**ADC Planning Consultation
Response from the Historic Buildings Adviser**

Application Number	BR/262/13/L
Address	Manor House, 12 Chichester Road, Bognor Regis, PO21 5BP
Description	Application for Listed Building Consent for conversion of existing listed building currently vacant to provide 4no flats. Demolition of single storey building at rear and construction of single storey extension and separate 2 storey building to provide 5no flats (9 in total).
Case Officer	Peter Cleveland
Site Visit	Previous

Objection

DRAWING TITLE
PROPOSED ELEVATIONS
SHEET 1

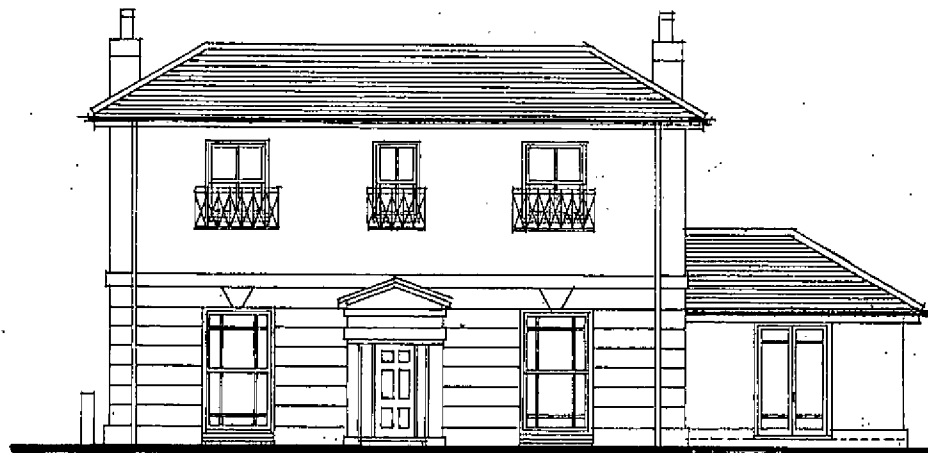
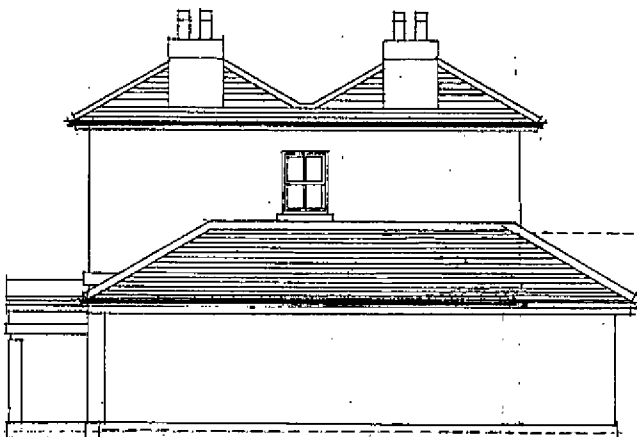
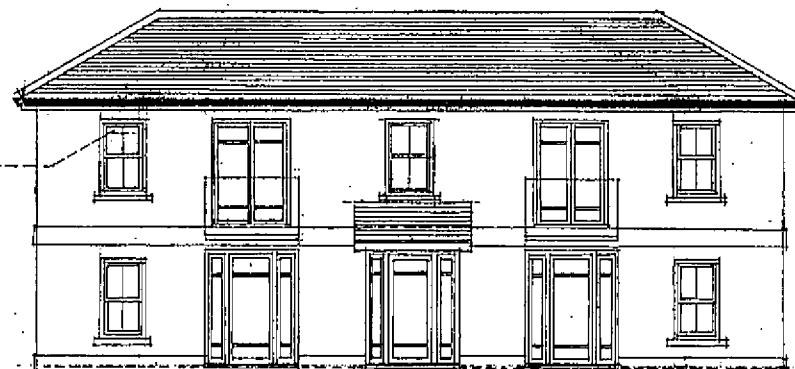
The proposed addition to the side, whilst subservient in height, has an excessive footprint which is not sympathetic with the listed building or its plan. The large area of flat roof is also inappropriate.

DRAWING TITLE
PROPOSED ELEVATIONS
SHEET 2

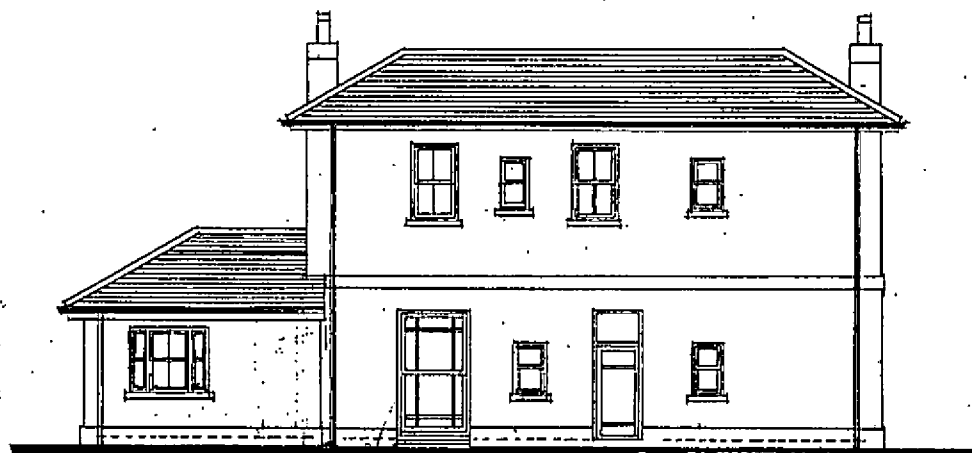
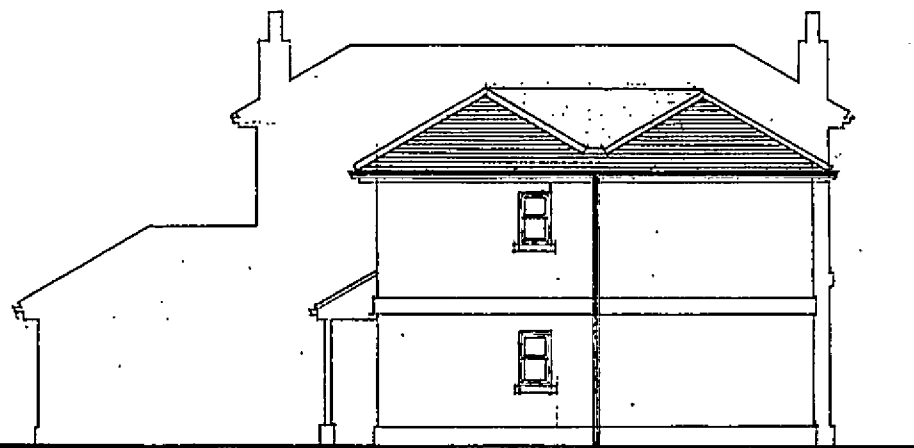
The development of the extension to the rear into a two storey block of flats is also not acceptable. Whilst a single-storey addition may have been justified in providing a care facility, this broader public benefit is not relevant here. The new proposal instead represents overdevelopment within the setting of a listed building - one that directly competes with it in terms of both scale and massing. Para 132 of the NPPF advises authorities that 'when considering the impact of a proposed development on the significance of a designated heritage asset, great weight should be given to the asset's conservation..... Significance can be harmed or lost through alteration or destruction of the heritage asset or development within its setting.'

CLIENT
CS PROPERTY AND CONSULTANCY LTD
PROJECT
**MANOR HOUSE, 12 CHICHESTER ROAD
BOGNOR REGIS PO21 2XE**
DRAWING TITLE
PROPOSED GROUND FLOOR PLAN
SCALE
1/100 at A3
REFERENCE
11332.05 A

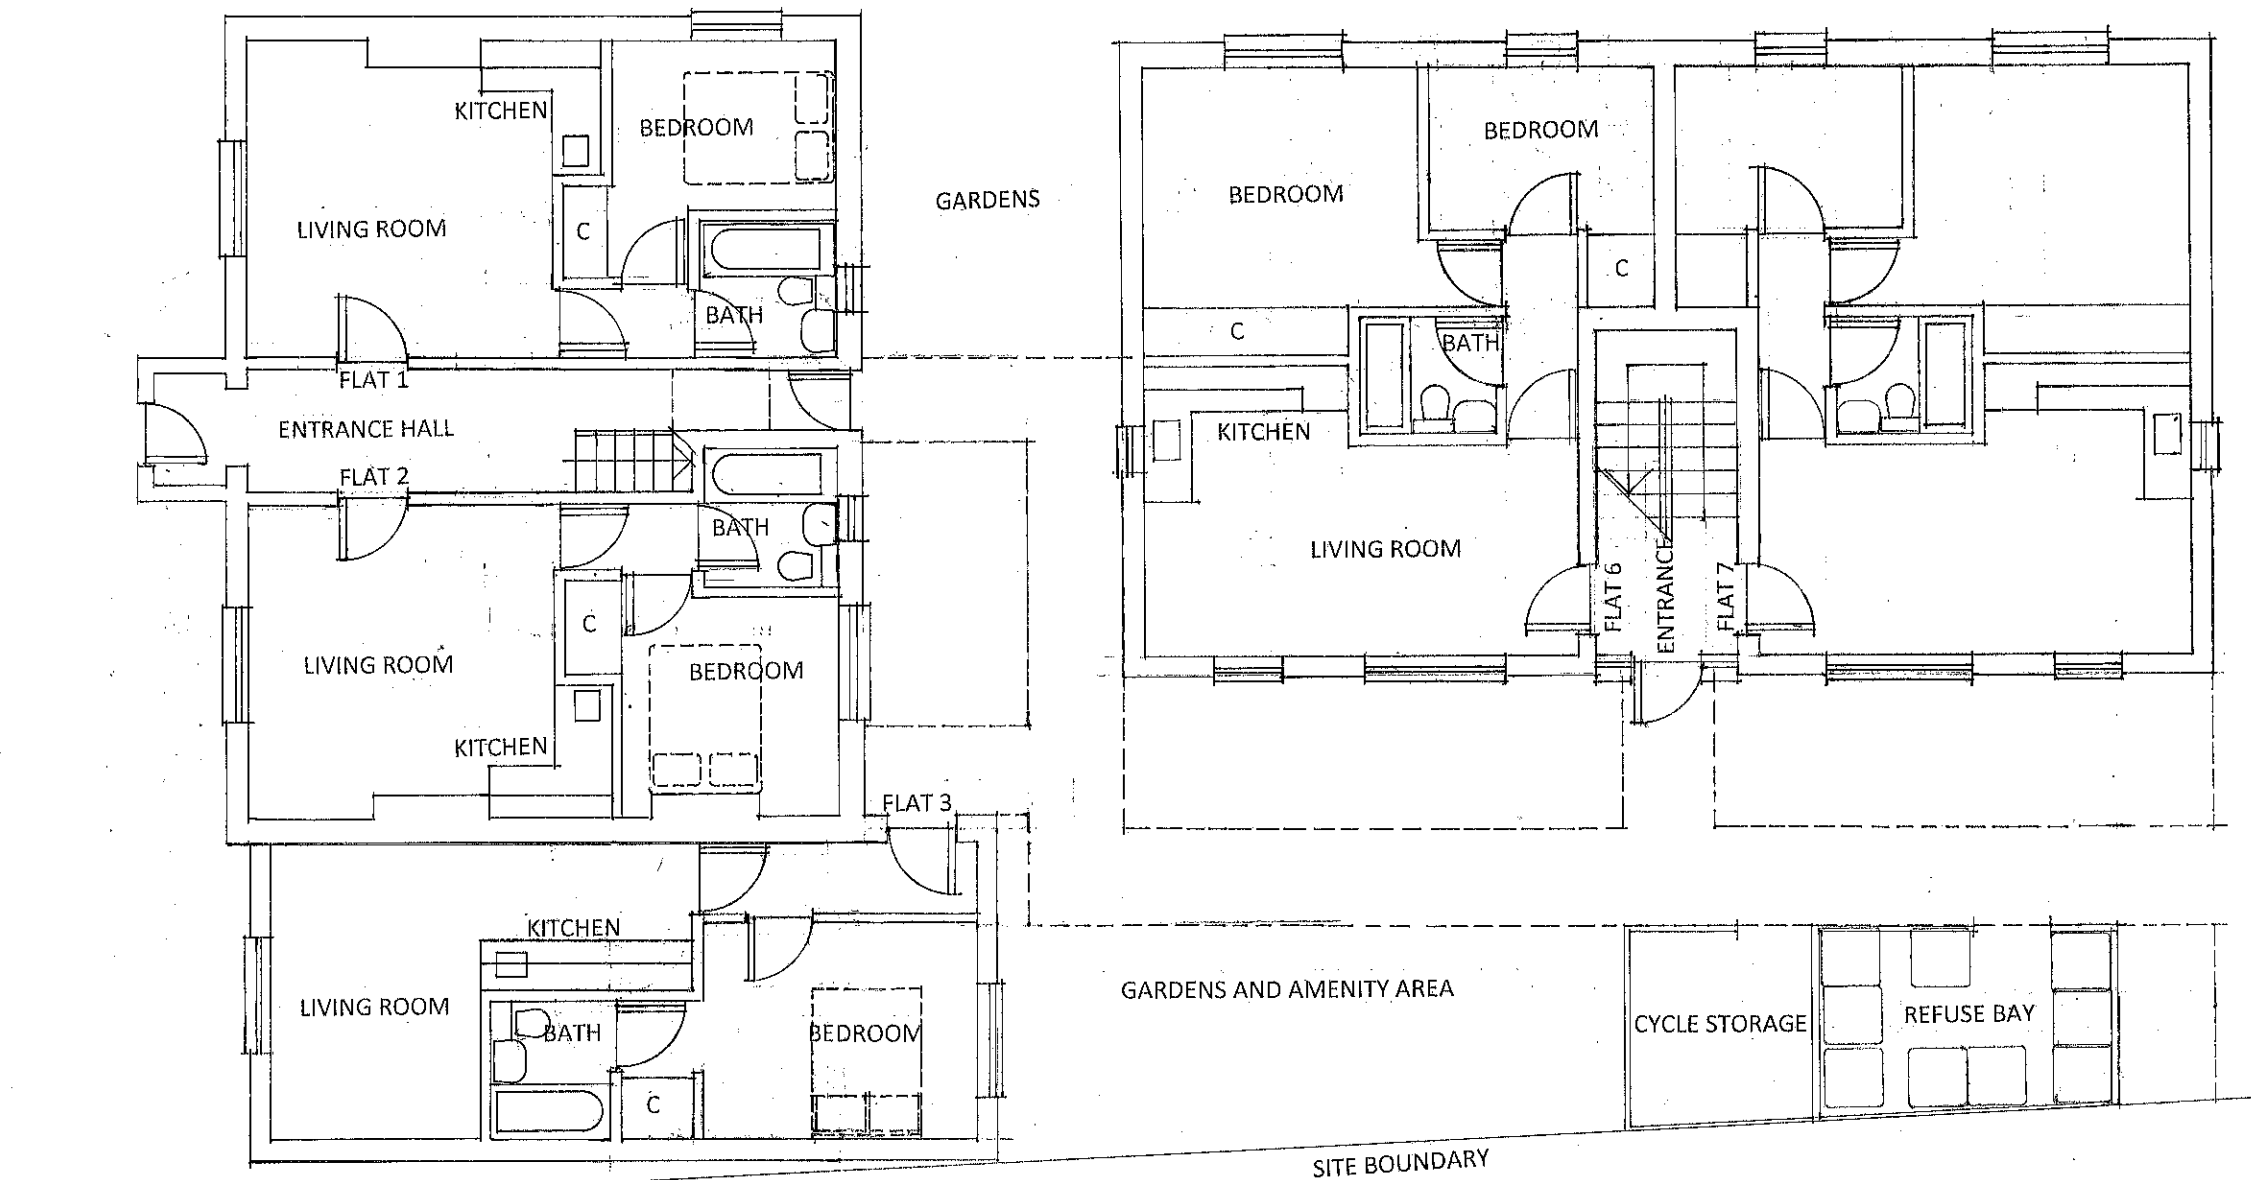
Internally the proposed alterations appear wholly unsympathetic, particularly as the building has a strong cellular plan. Whilst there may be some alteration here, the total disregard for the plan and the nature of the subdivision is extremely problematic. Authorities are required to protect the quality of

internal spaces as part of the building's special interest. Para 182 of EH guidance clearly states:

'The plan form of a building is frequently one of its most important characteristics and internal partitions, staircases ... and other features are likely to form part of its significance. Indeed they may be its most significant feature. Proposals to remove or modify internal arrangements, including the insertion of new openings...will be subject to the same considerations of impact on significance (particularly architectural interest) as for externally visible alterations.'
